Notice of Modification

The development consent SSD-6084 for the Austen Quarry Extension Project, granted by the delegate for the Minister for Planning on 15 July 2015.

Figure 2: Development Layout of Austen Quarry and Conservation Area H

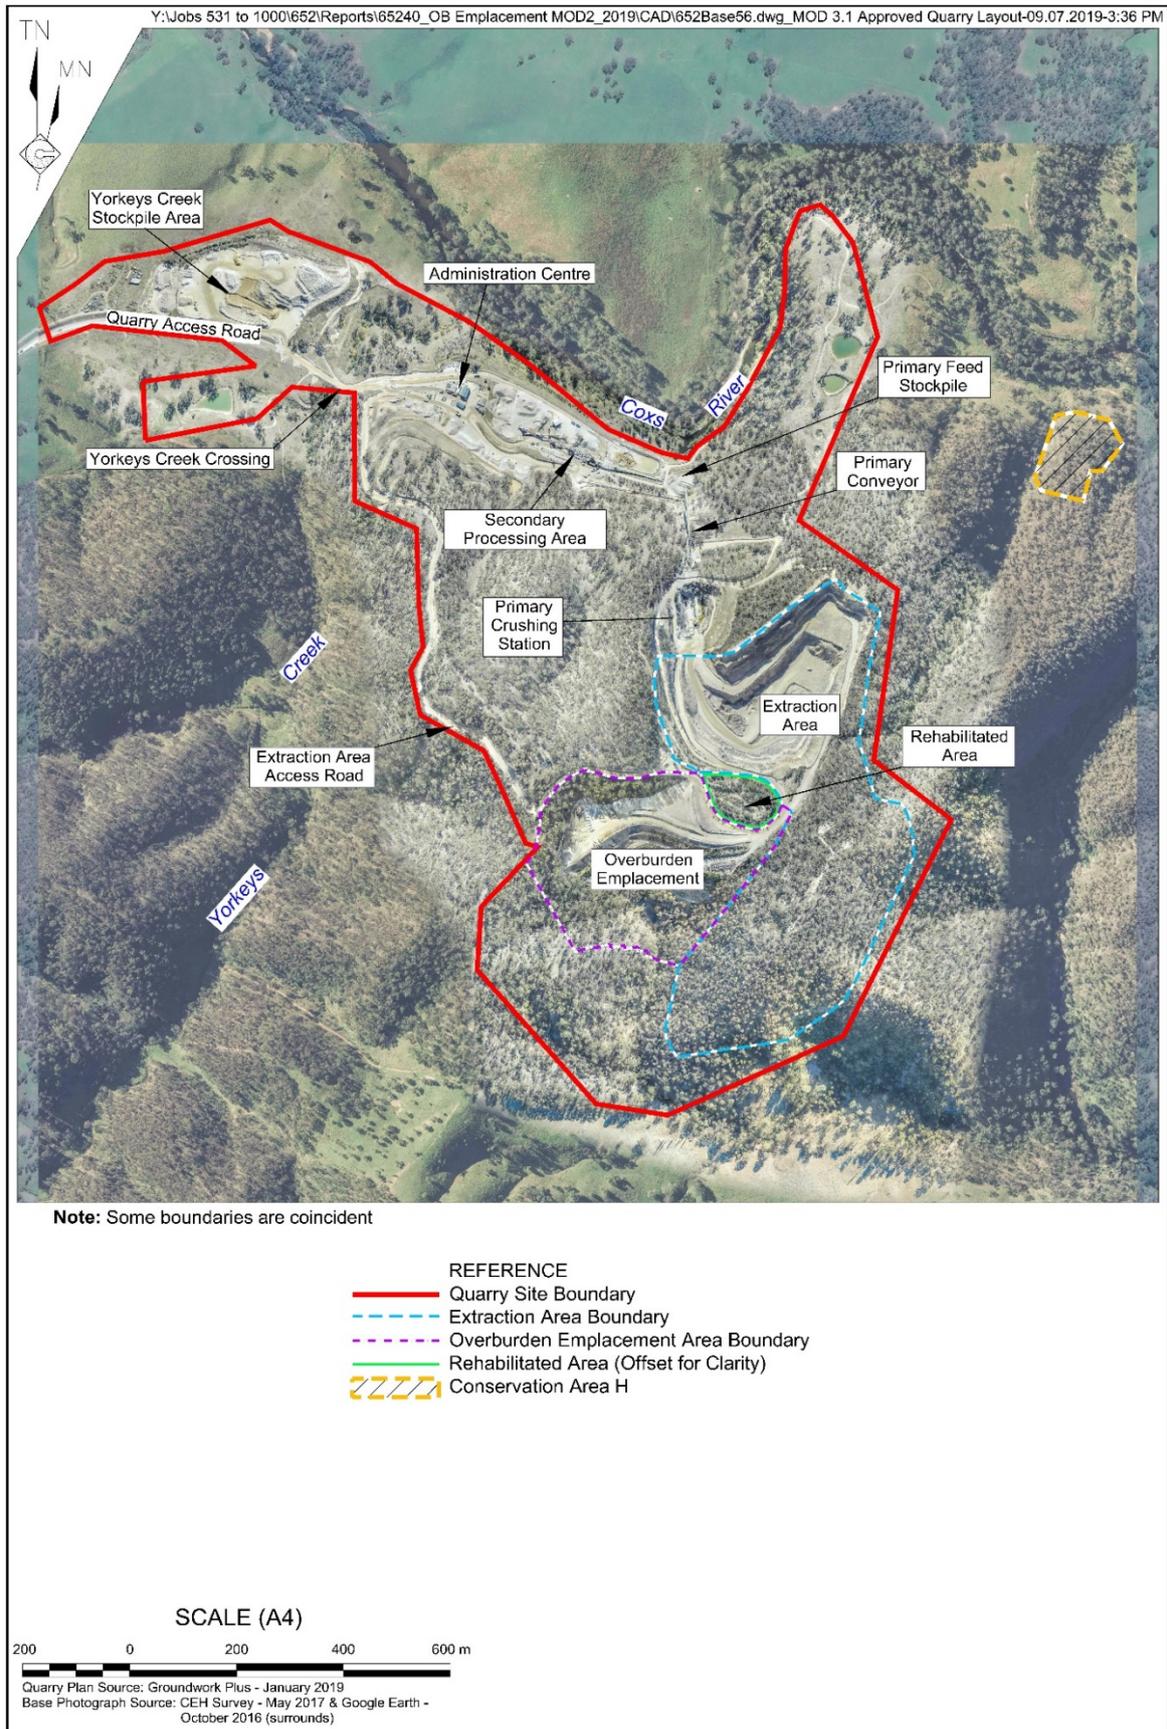
2. In the Table of Contents, delete “CONSERVATION AREA H”.
3. In the list of definitions and in Schedule 3, delete “Appendix 6” wherever occurring and replace with “Appendix 2”.
4. In condition 2(a) of Schedule 2, after “(Mod 1)” insert “ and SEE (Mod 2)”.
5. In Appendix 2, delete the figure and replace with:

Figure 3: Conceptual Final Landform aerial view

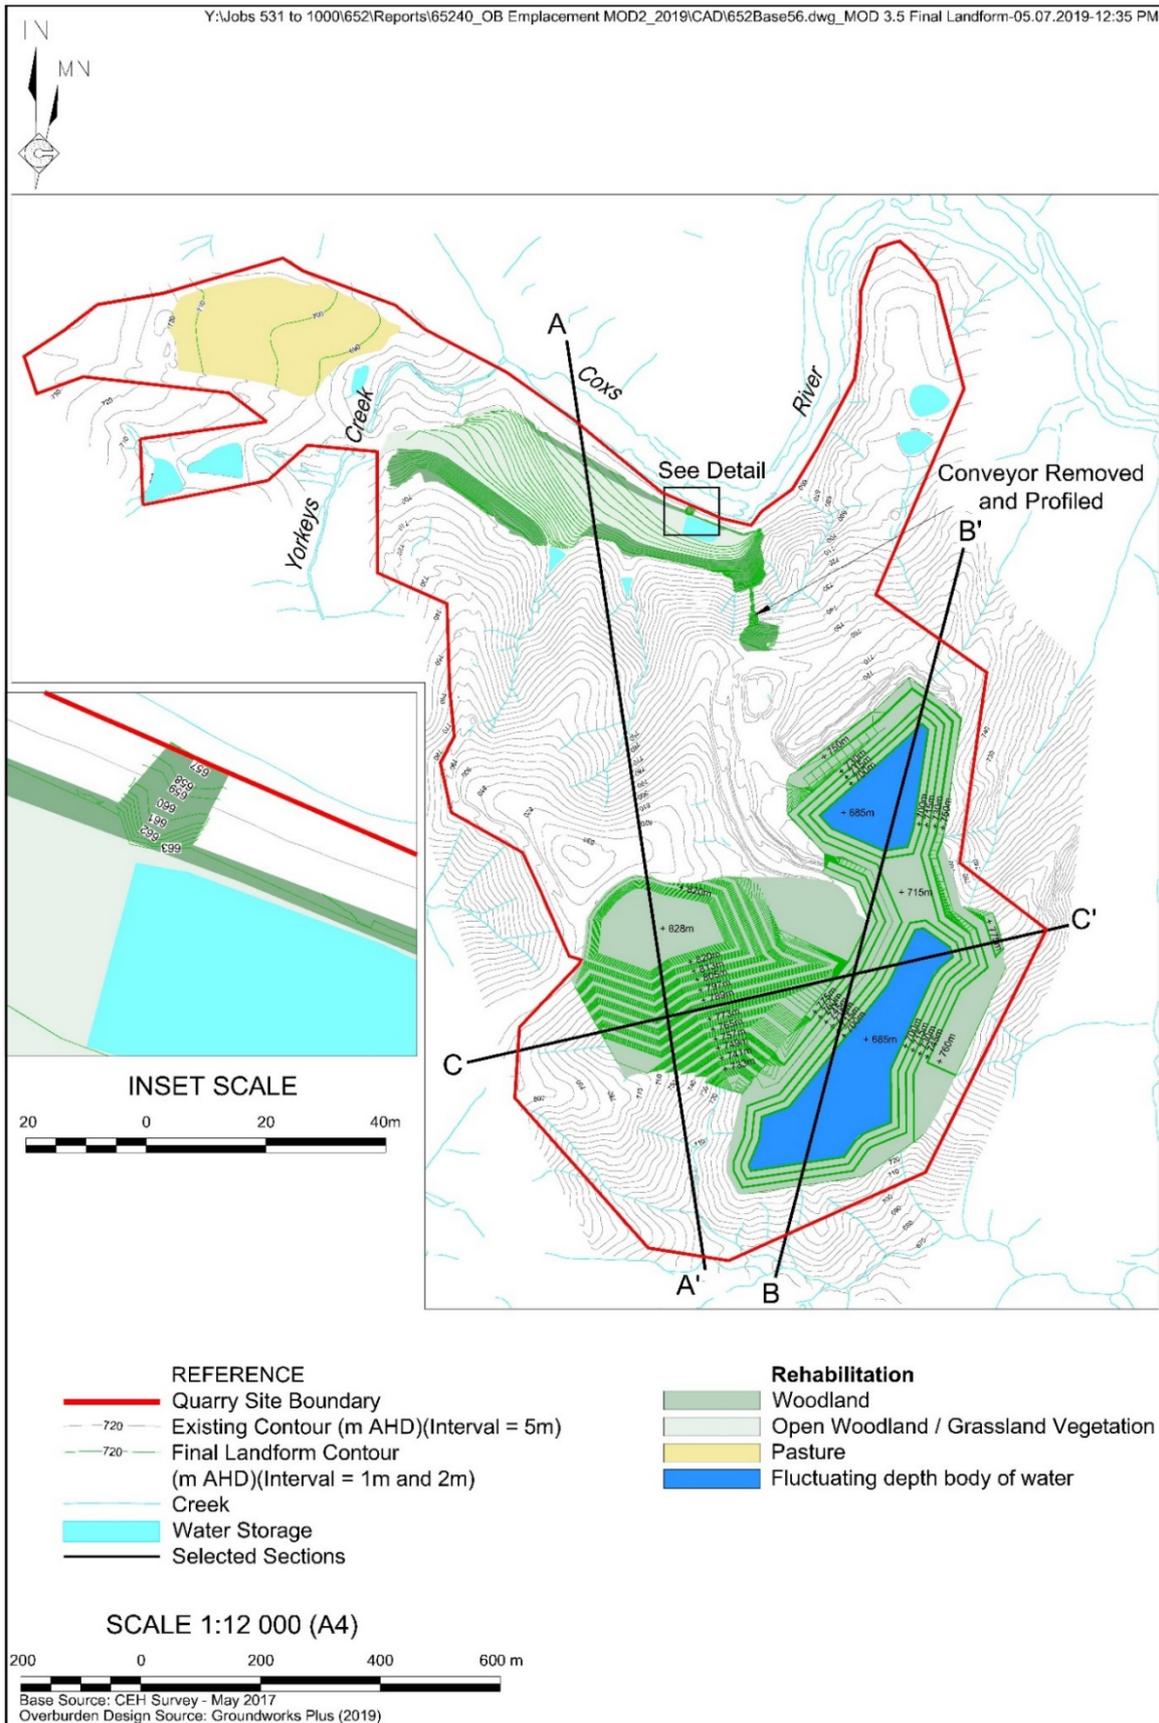
7. Delete Appendix 4 and replace with the following:
